ASSESSMENT REPORT

Section 75W Modification Mixed Use Development (MP09_0121 MOD 1) Ettalong Beach

01 North Elevation 1:200@A1

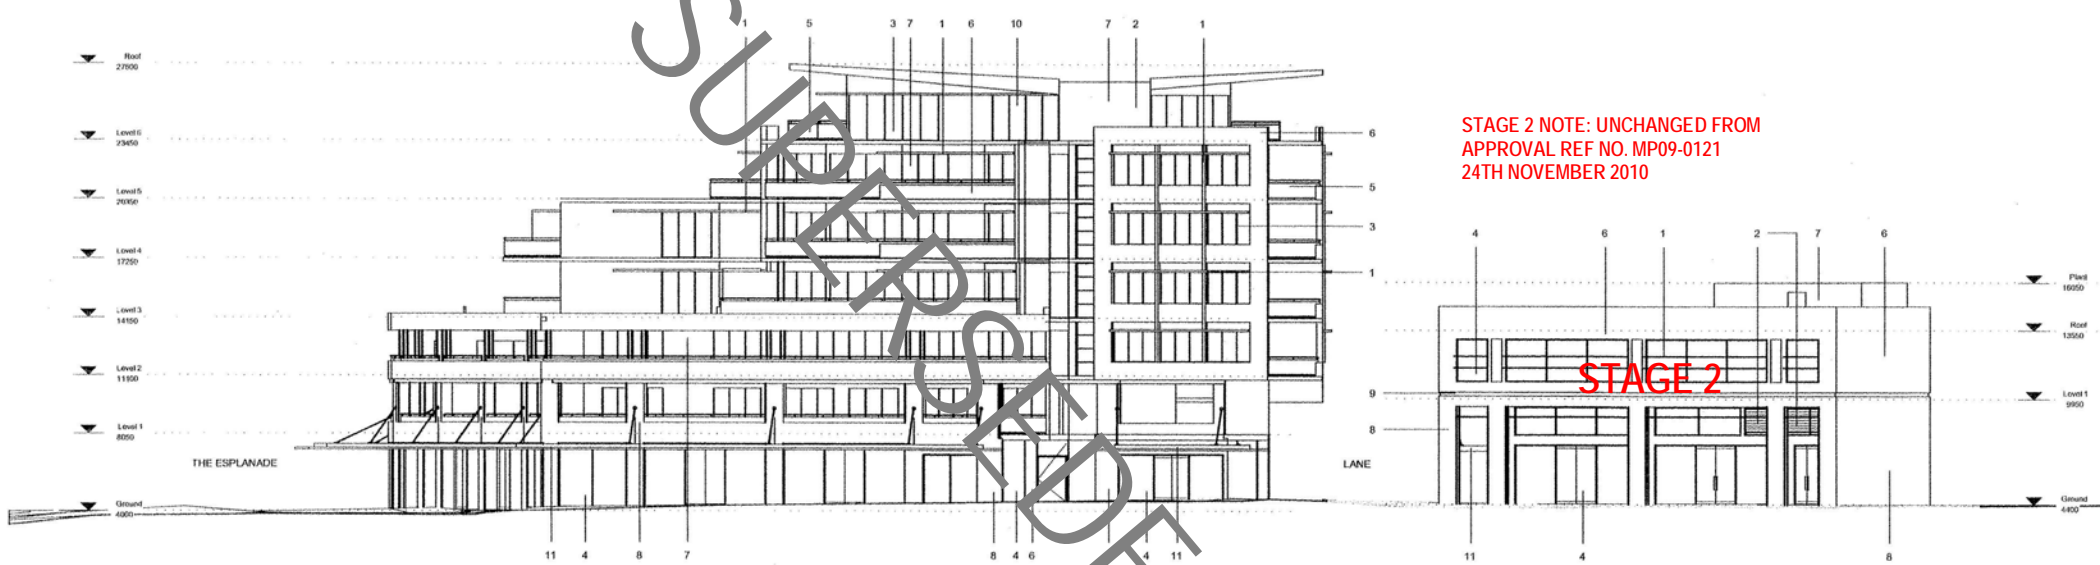
However, Council raised a concern with the design of the northern elevation facing the laneway which incorporates only blank walls and roller shutters. Council suggested the proposal should be amended to include some areas of landscaping to contribute to the streetscape and to soften the appearance of the blank walls.

In response to Council's concerns, the Proponent amended the plans to incorporate landscaping to the rear footpath adjacent to the laneway. The Department considers the landscaping results in an improvement to the presentation of the building to the rear laneway. However, the Department also notes that the approved scheme incorporated windows facing onto the laneway from the two retail tenancies at either end of the laneway. The modification seeks to delete the windows, resulting in reduced visual interest and reduced activation and casual surveillance of the laneway. The Department therefore considers that the windows should not be deleted and has recommended a condition requiring the windows to be reinstated.

Subject to the additional landscaping and incorporation of additional windows to the rear laneway, the Department is satisfied that the proposed modifications result in an improved outcome in terms of the design of the building and its presentation to the surrounding streets.

Drawing Title
**LEVEL 02
FLOOR PLAN**

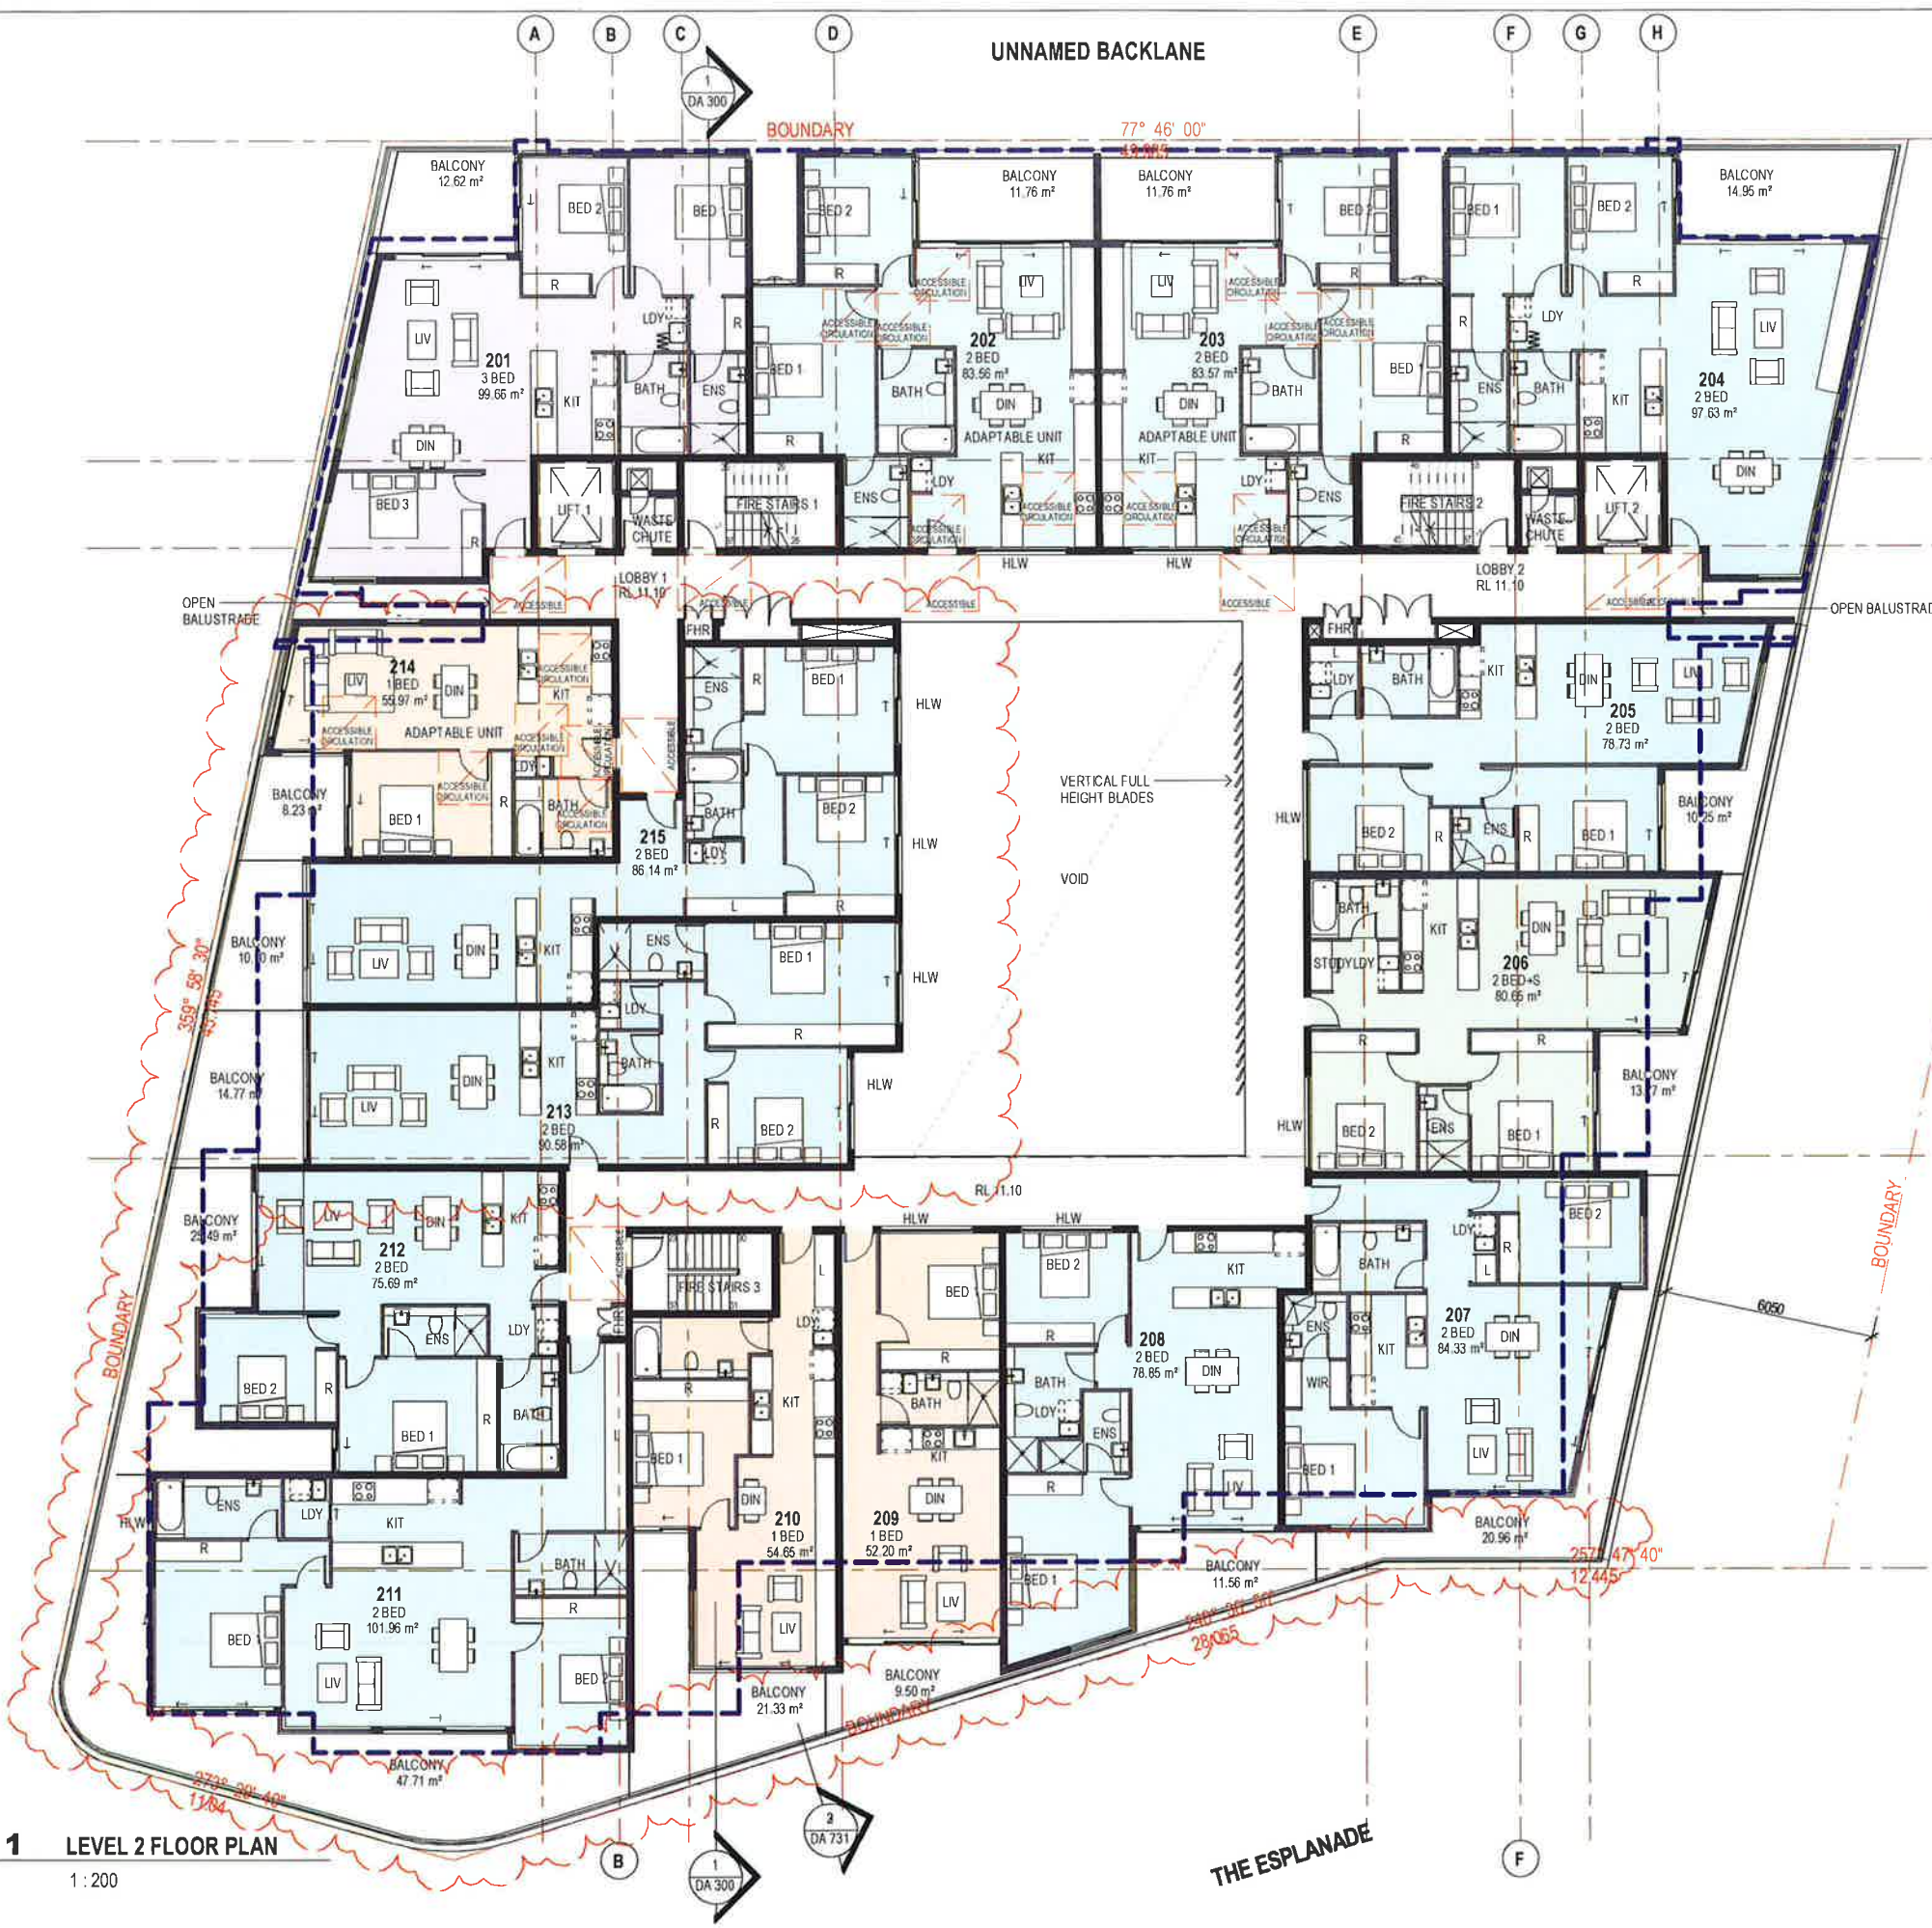
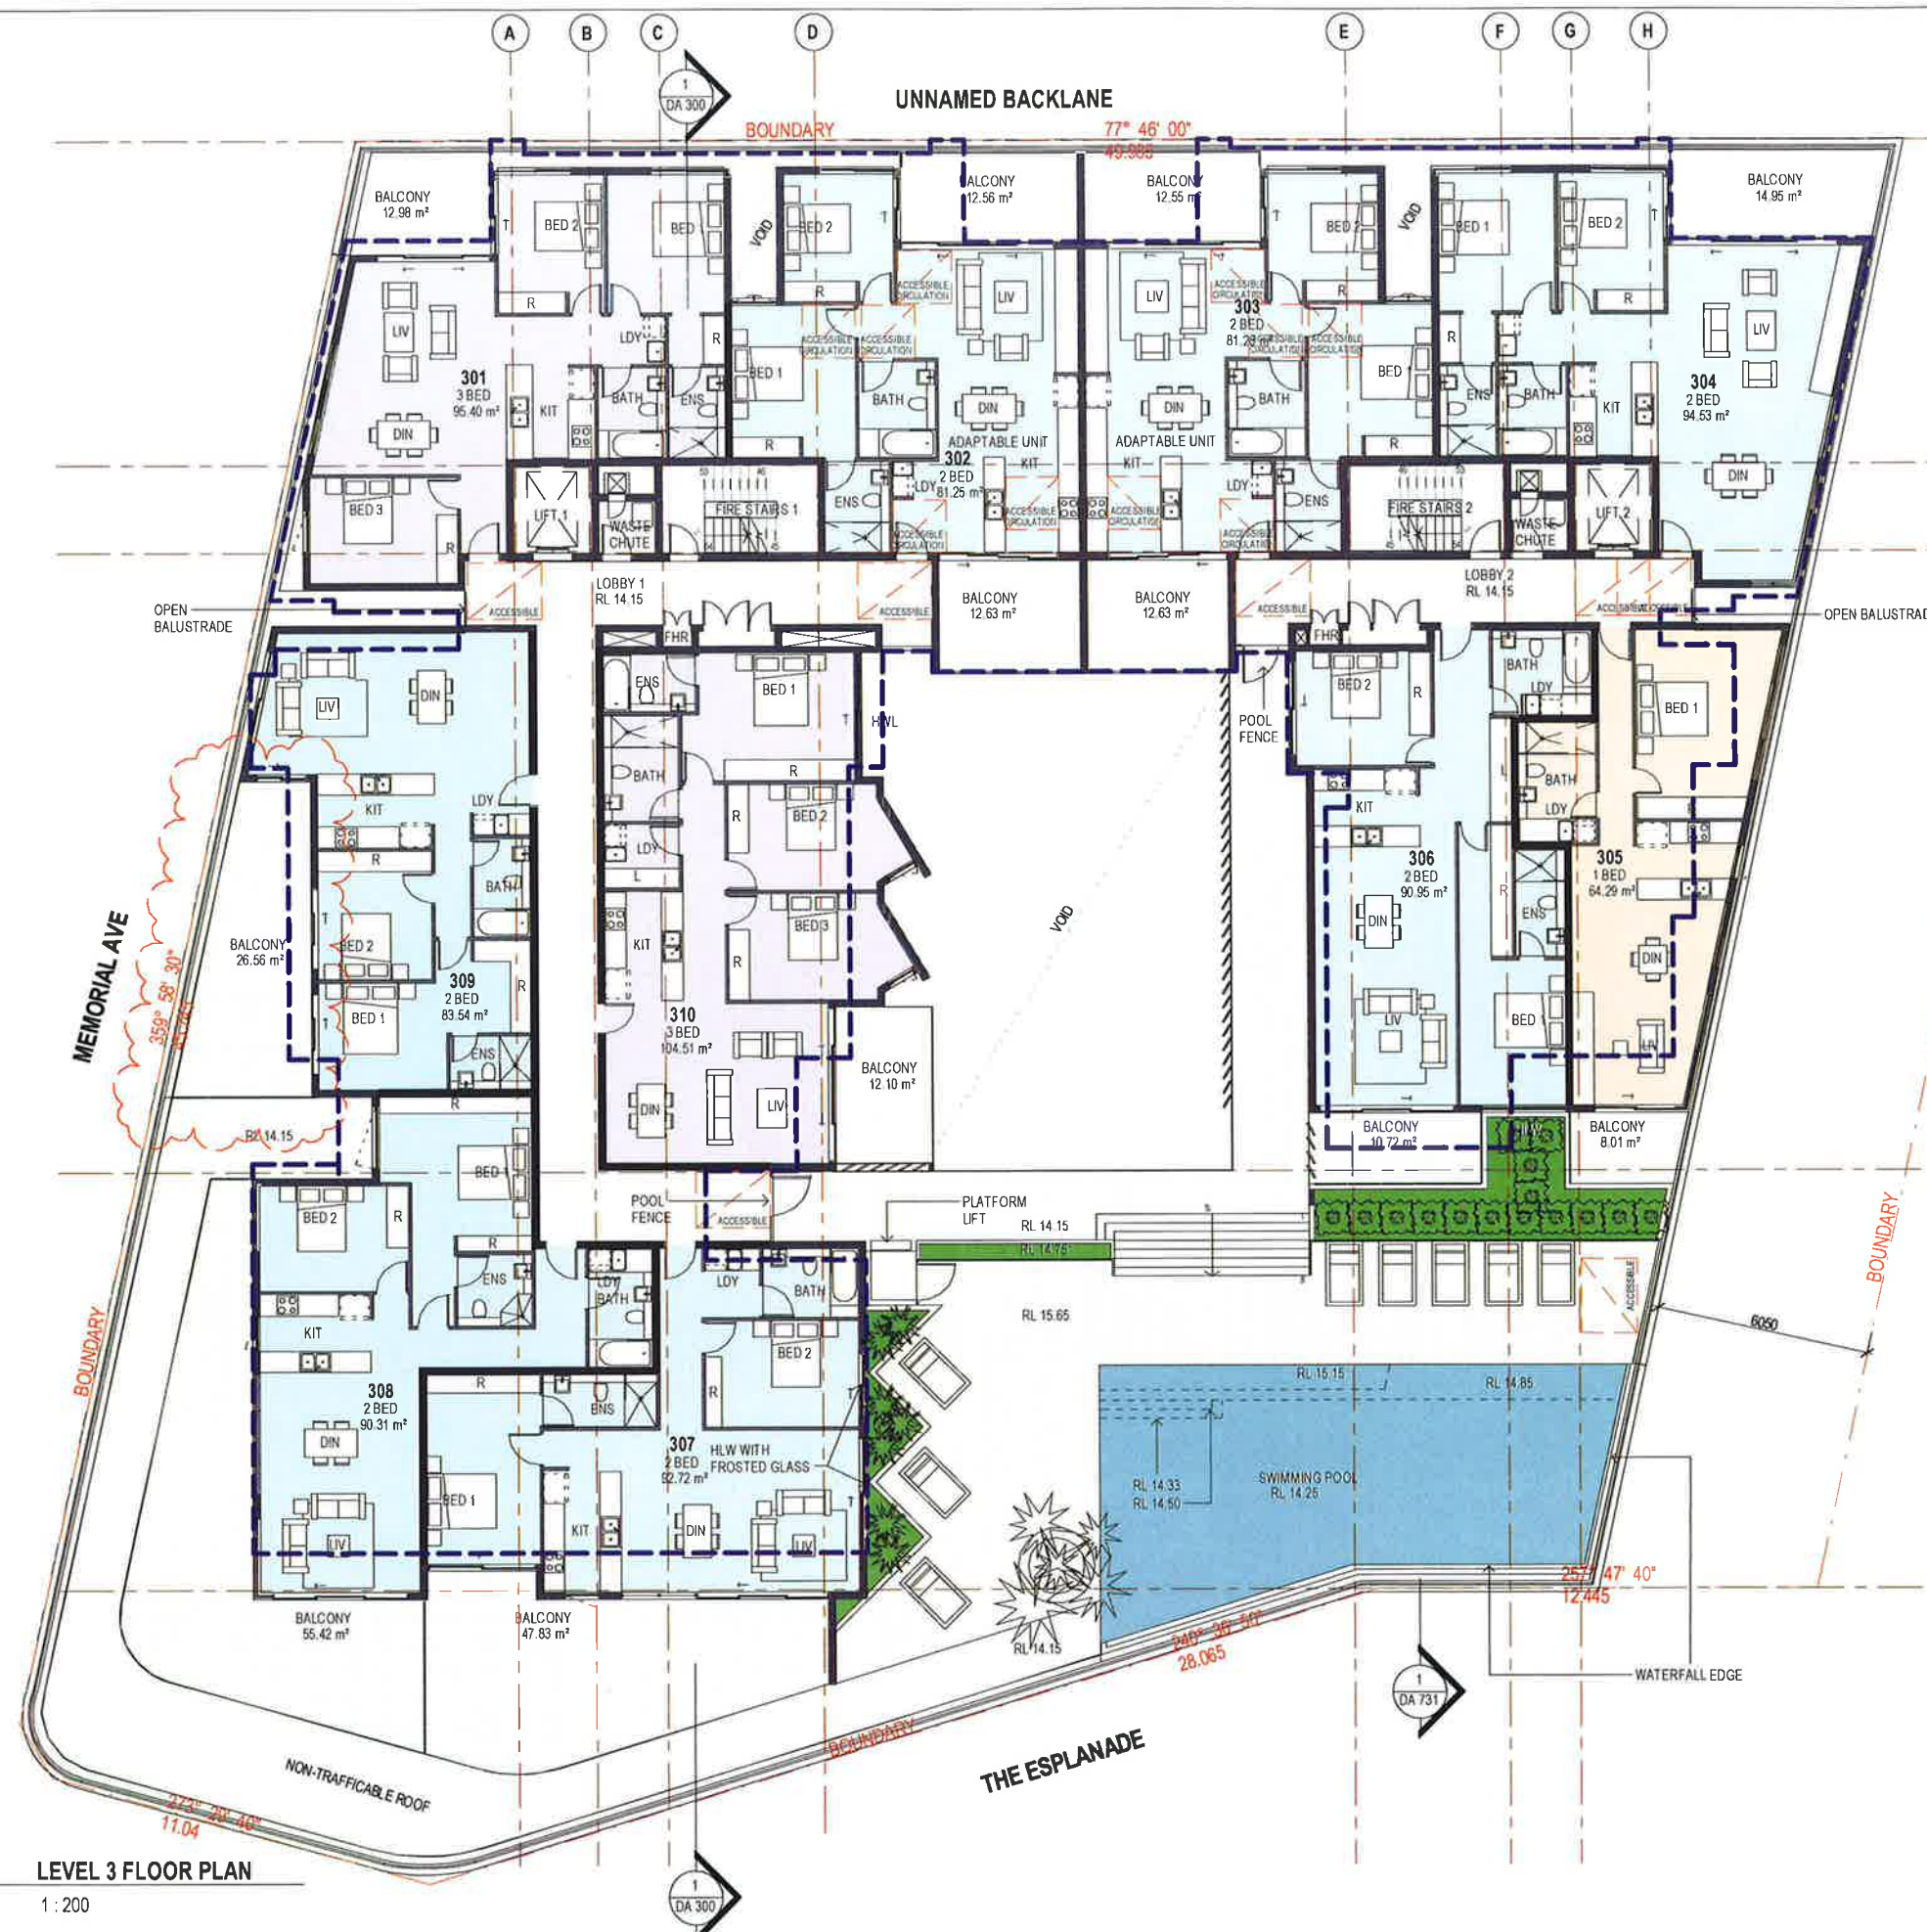
Following an initial assessment, concerns were raised by Council and the Department with regard to the amenity of some proposed internal units at the lower levels which would have limited outlook, privacy and solar access.

To address these concerns, the Proponent subsequently reconfigured the floor plans so that all units at levels 1 and 2 have a frontage to the external facade of the building, ensuring good levels of solar access, ventilation and reasonable levels of privacy. It is also noted that while concern was raised by Council in relation to a similar unit at level 3, this unit retains a very similar layout to the unit previously approved at this level. Further, the unit is not an 'internal unit' in that it has access to views and outlook over the communal pool area and the waterway, and would retain a similar level of amenity as the previously approved unit at this location.
